21 November 2013

**RE: Sydney International Convention, Exhibition and Entertainment Precinct
(SICEEP) - International Convention Centre Hotel (ICC Hotel) [SSD 13_6116]**

## View Selection within the View and Visual Impact Assessment

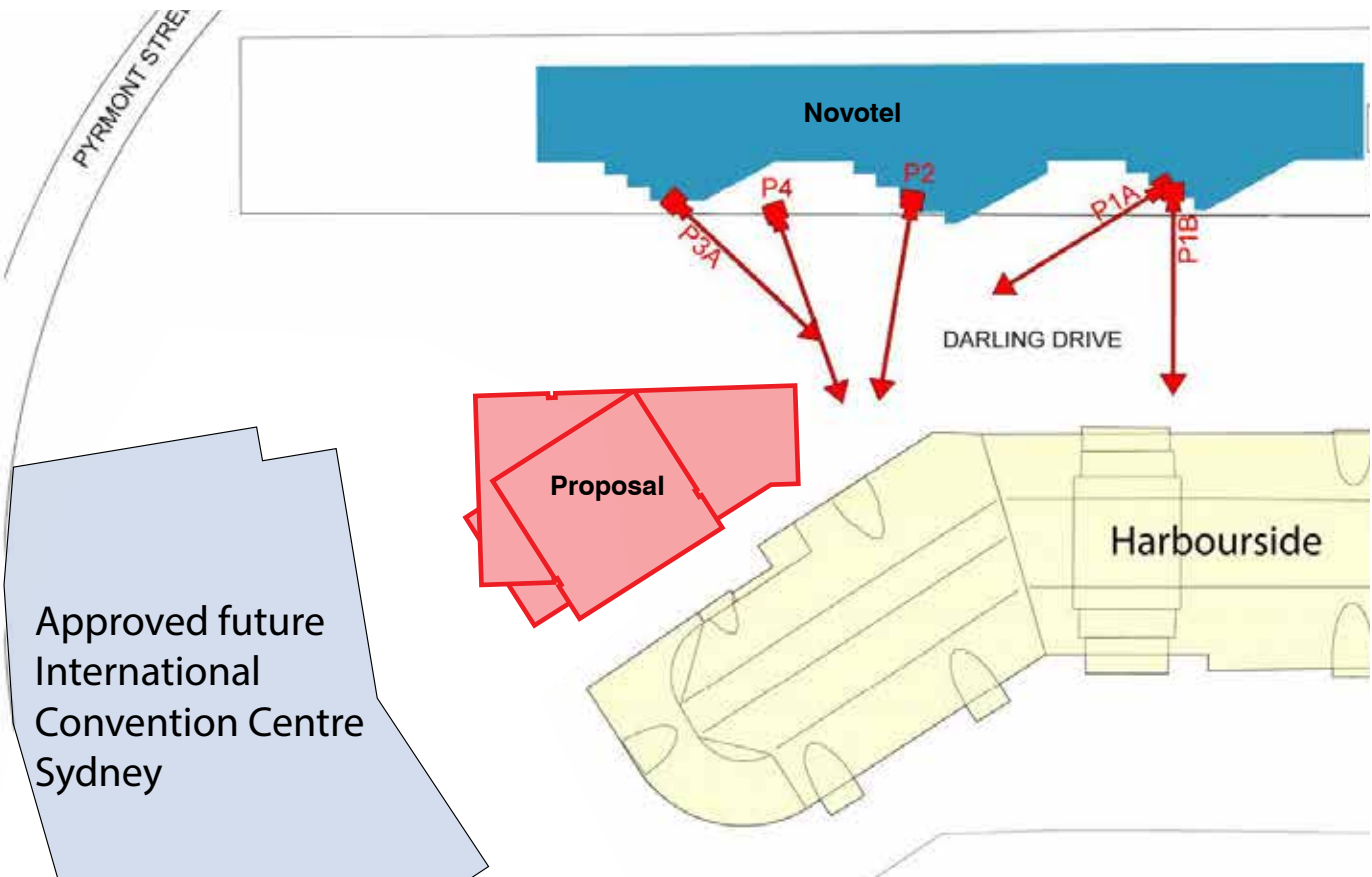
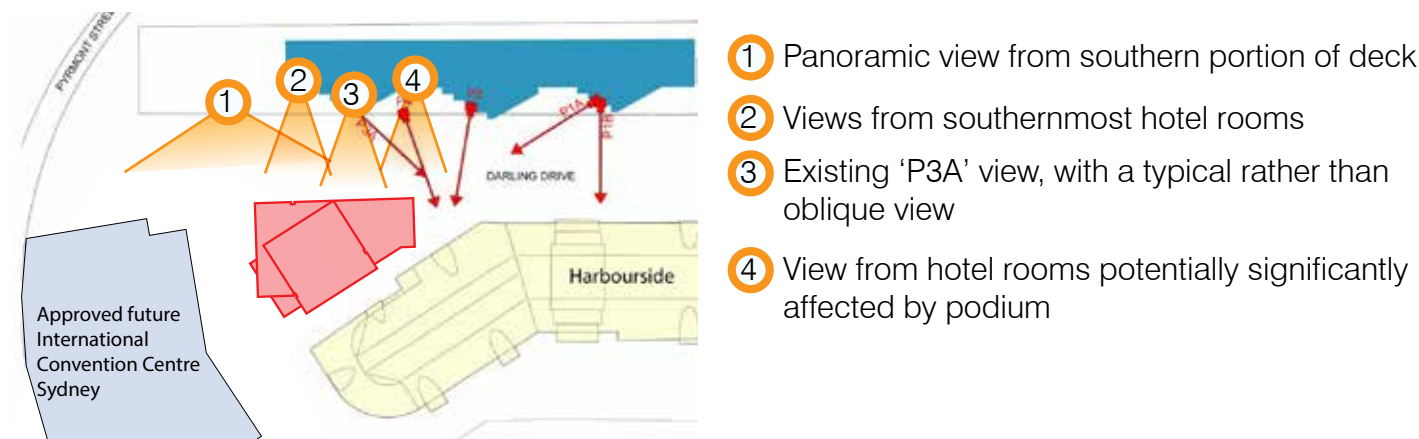
The selection of views provided within the VVIA document includes oblique angles, particularly from the south of the Novotel. These are focussed away from the proposal, minimising its apparent impact.

Attachment A to this submission includes example photographs demonstrating typical views from these hotel rooms and their narrow aspect. It also includes a plan showing the views selected by the applicant, with the proposal included, showing that the views selected clearly focus away from the proposal.

1. It is recommended that the VVIA be amended to:
 - Test the actual views from the hotel room, as shown in **Attachment A** showing before and after shots for each view.
 - Undertake a thorough assessment of each view.
2. That the revised VVIA be distributed to Accor for comment, prior to the Department's assessment of the application.
3. That Accor have the opportunity to provide further comment, once the VVIA has been provided.

## Demonstration of existing view from Hotel window and actual view loss (1/3)

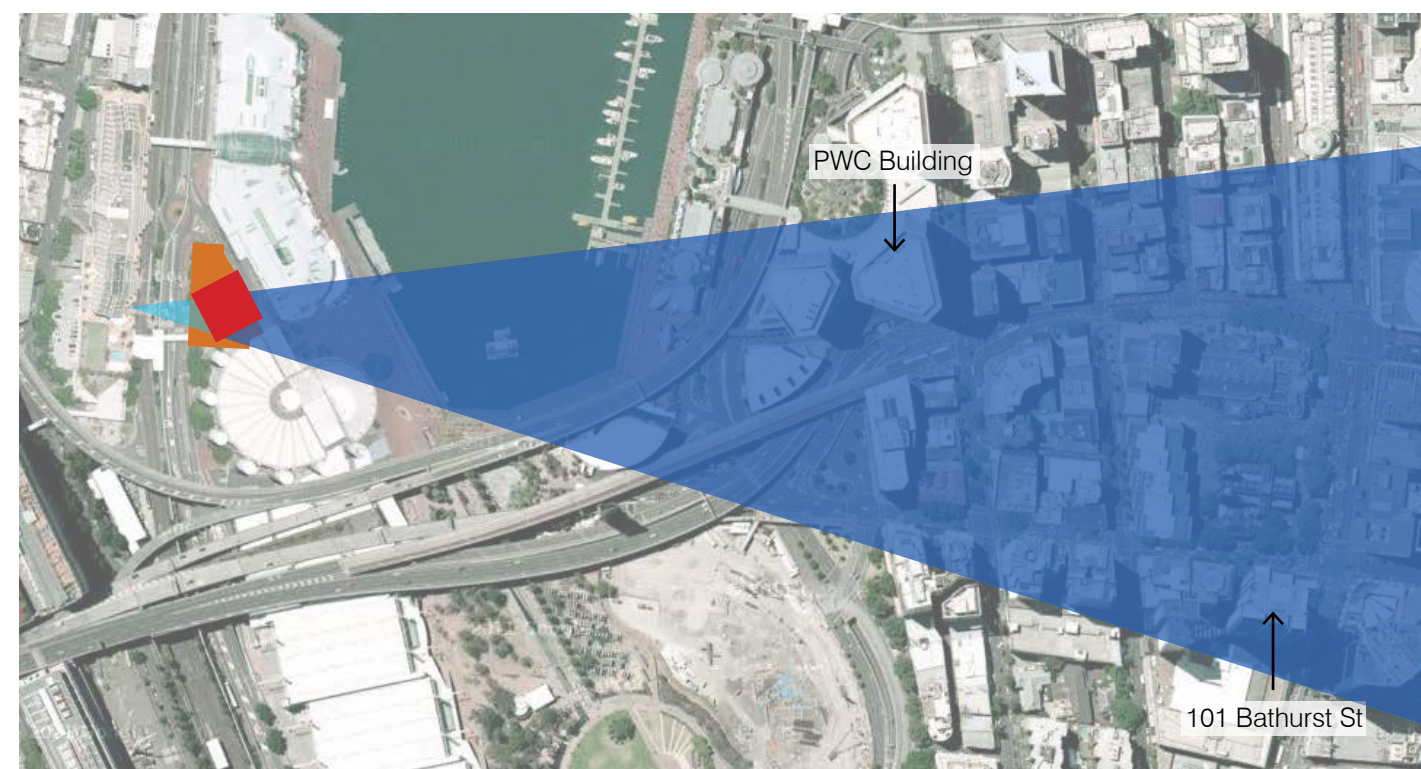
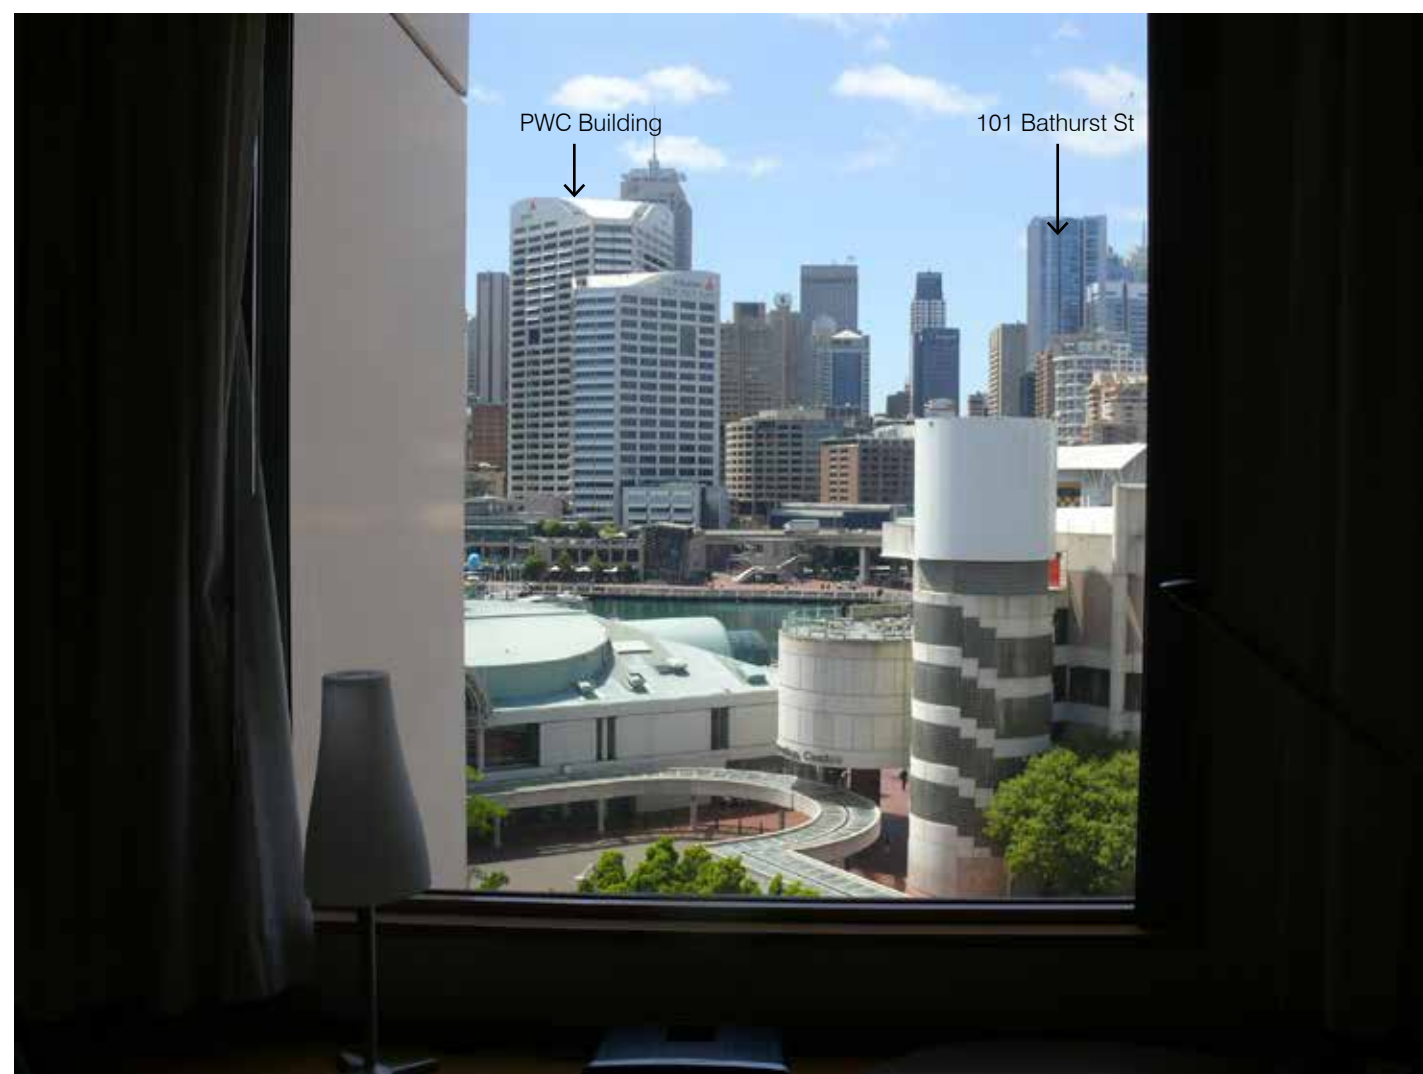
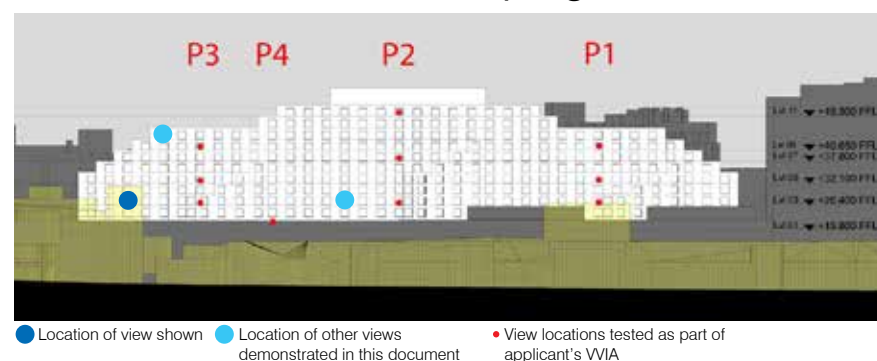
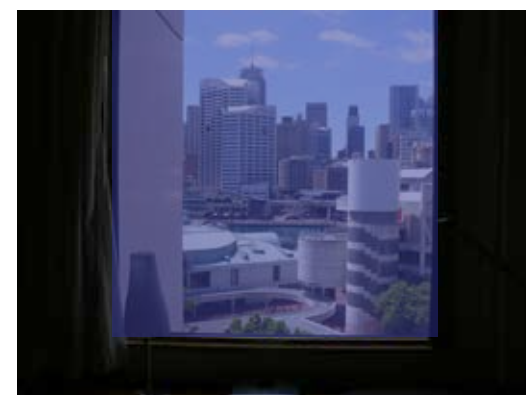
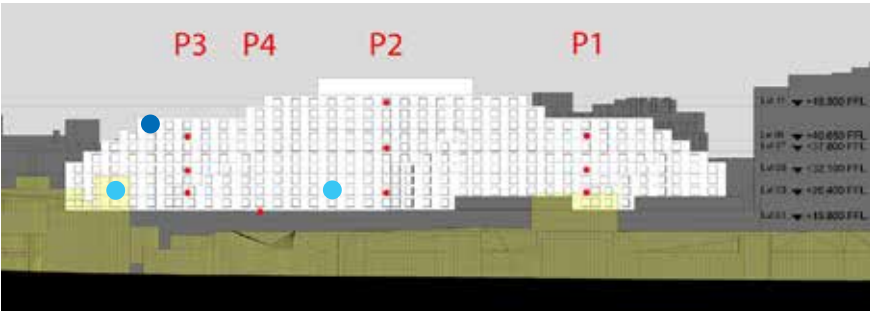
Views assessed do not represent actual views

These oblique views are also not typical of the actual views obtained from the hotel rooms, where the window frames and width of rooms is such that views obtained are usually directed straight out the window and oblique views (such as those shown) are not easily obtained. The views shown are therefore not representative of the existing views and do not demonstrate the actual extent of view loss for the hotel rooms.

Due to the above, we do not consider that the view impacts noted within the VVIA document accurately describe the impact which the proposal will have on the Novotel. For instance, the proposal is noted to be “a minor encroachment” to view 3A where Architectus would consider that the impact to these hotel rooms is likely to be a severe loss of the existing view.

## Currently proposed podium massing - relationship with Darling Drive

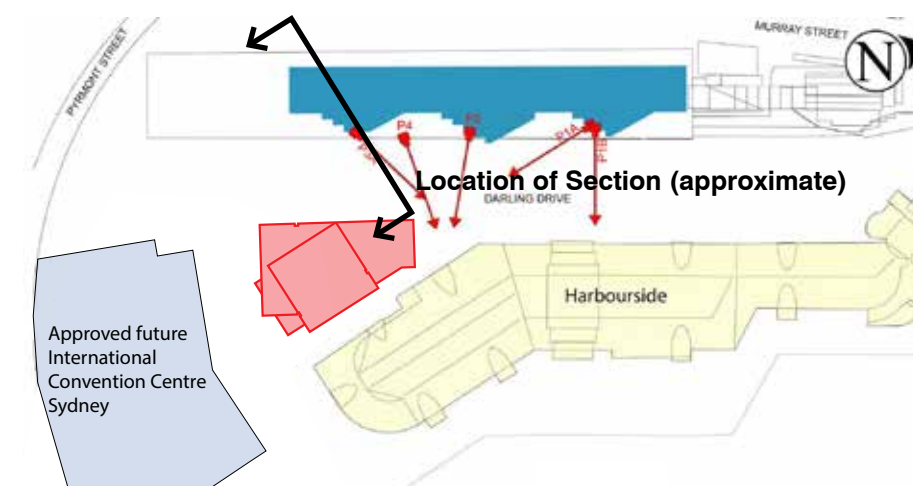
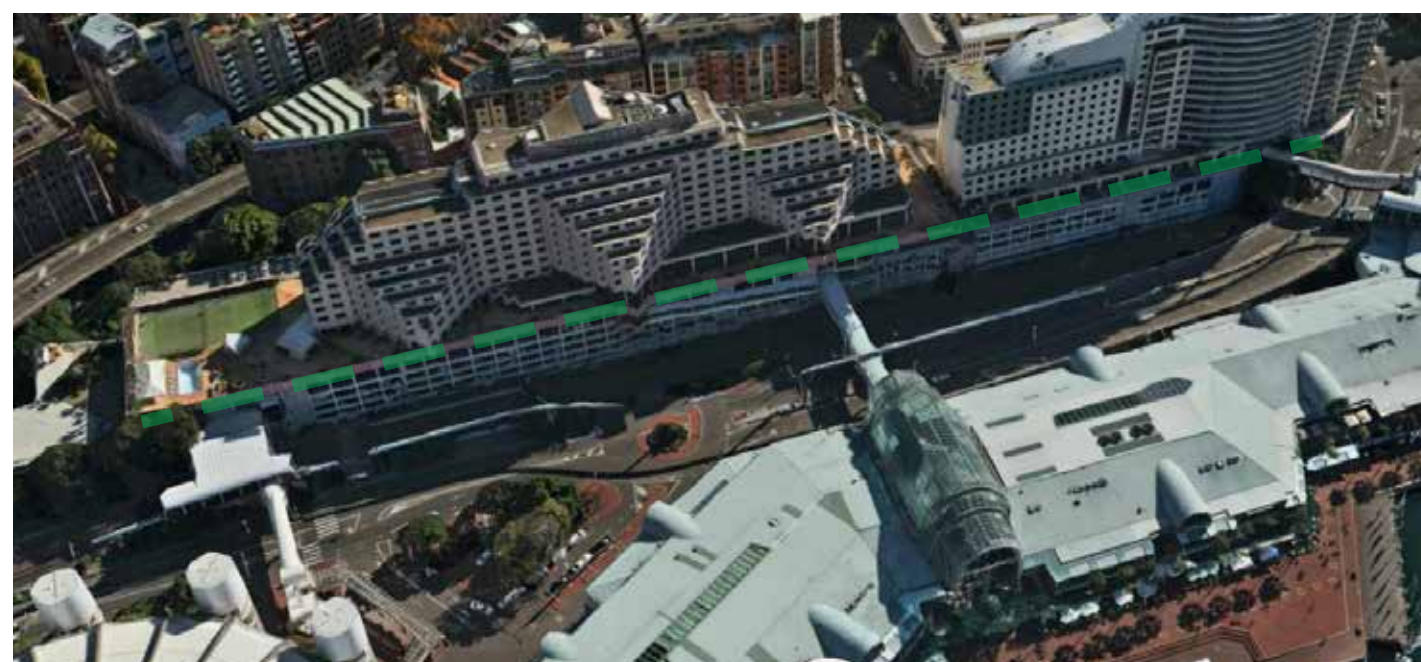
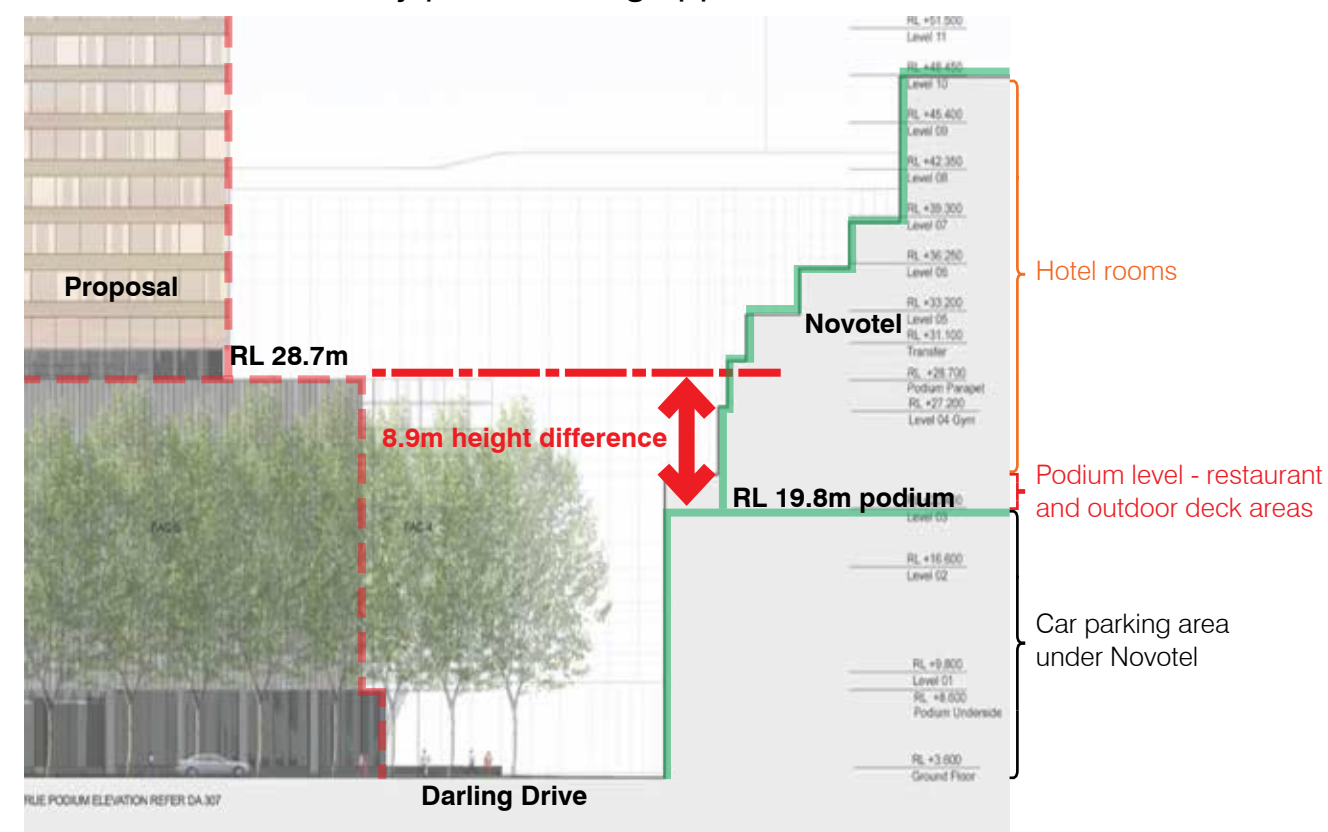
- **Bulk and scale of tower** - The tower form is effectively a simple square located as close as possible to Cockle Bay. Alternative design approaches such as a less 'square' profile or moving some of the tower bulk to the south or west could create better outcomes with regard to view sharing without necessarily sacrificing development capacity for the proposal.
- **Podium design** – The podium element of the proposal (at a height of 27.2m) is approximately two to three storeys above the Novotel 'deck' (height 19.8m). Importantly, this deck level accommodates the Hotel's restaurant, function areas and balconies, which are enjoyed by hotel patrons and the general public.

A lower podium element may be able to achieve better view sharing outcomes for the lower levels of the Novotel including the outdoor terrace (Level 1). It would also achieve a better streetscape outcome (providing a clear height relationship across the street) and could help the proposal to fit within its context. In order to provide a similar development capacity, some of the elements currently within this area of the podium could be moved to the basement (such as plant rooms) or potentially relocated to increase the height of the podium to the south (where the visual impact from the Novotel is lesser).

The proposed podium element that directly faces the Novotel Hotel is a sheer wall of approximately 25m height with little articulation. This 'back-of-house' façade would be the only view from many of the hotel rooms.

5. It is recommended that the VVIA document, its analysis and outcomes, be amended to include consideration of the New South Wales Land and Environment Court Planning Principles on view sharing, and identify how the built form can better respond to these principles.
6. That the Applicant provide plans showing a lowered podium as described in **Attachment B** and re-test the impacts on the Novotel Hotel.
7. That the Applicant provide plans showing an alternative tower location and form as described in **Attachment B** and re-test the impacts on the Novotel Hotel.
8. That the Applicant makes these plans available to Accor prior to the determinations of the application.
